PO/8/21/L

Peckhams Poling Street Poling BN18 9PT

Listed building consent for the renovation of stable block to create a single storey timber framed barn style building for home office use with lean-to extension

Approximate total gross internal
floor space - 68.2 m²
734 ft²

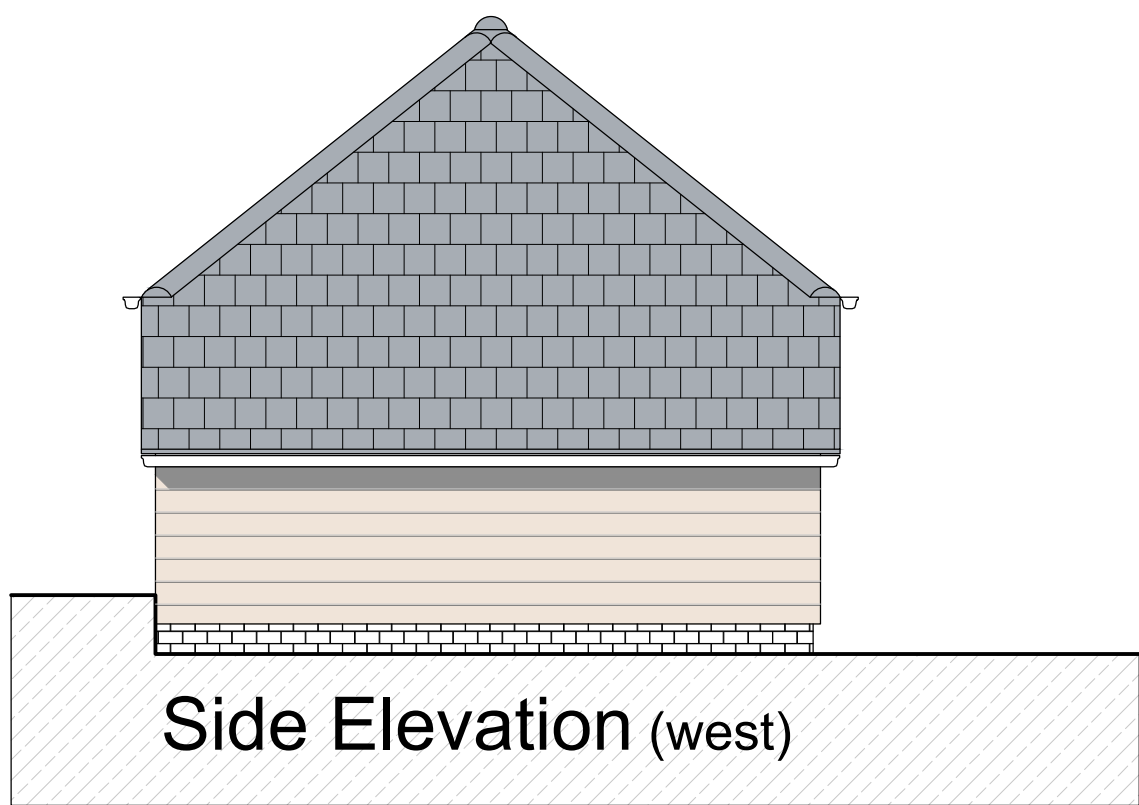
The proposed retention, refurbishment and re-use of the building is positive. It is also positive to see that the intention is for the front elevation to remain fairly simple in appearance with three openings. However, one of the statements associated with the application identifies that the timber frame to the front elevation is to be retained on show by the installation of timber panels or glazing between the framework rather than being covered up as currently exists. However, this is not clear if the existing ones will be relocated in order to accommodate the large central glazed area, nor if the existing staddle stones will be re-used. Please can this be confirmed. Also it would help to understand how the wood is to be treated, and further details of the windows/doors. Details of both of these can be provided for by way of condition, if you are minded to approve the application.

The proposed internal alterations appear to be reversible and are therefore acceptable. It would help to understand if the rooms are to be left open to the roof void. Such an approach ensures that the character of the existing space can be understood as opposed to the installation of modern ceilings, which is a feature not associated with agricultural buildings such as this. This also needs to be confirmed.

The addition of the bike store is carefully considered and will not harm the significance of the structure. My suggestion would be that the former external wall is left untreated so that it can still be seen/understood.
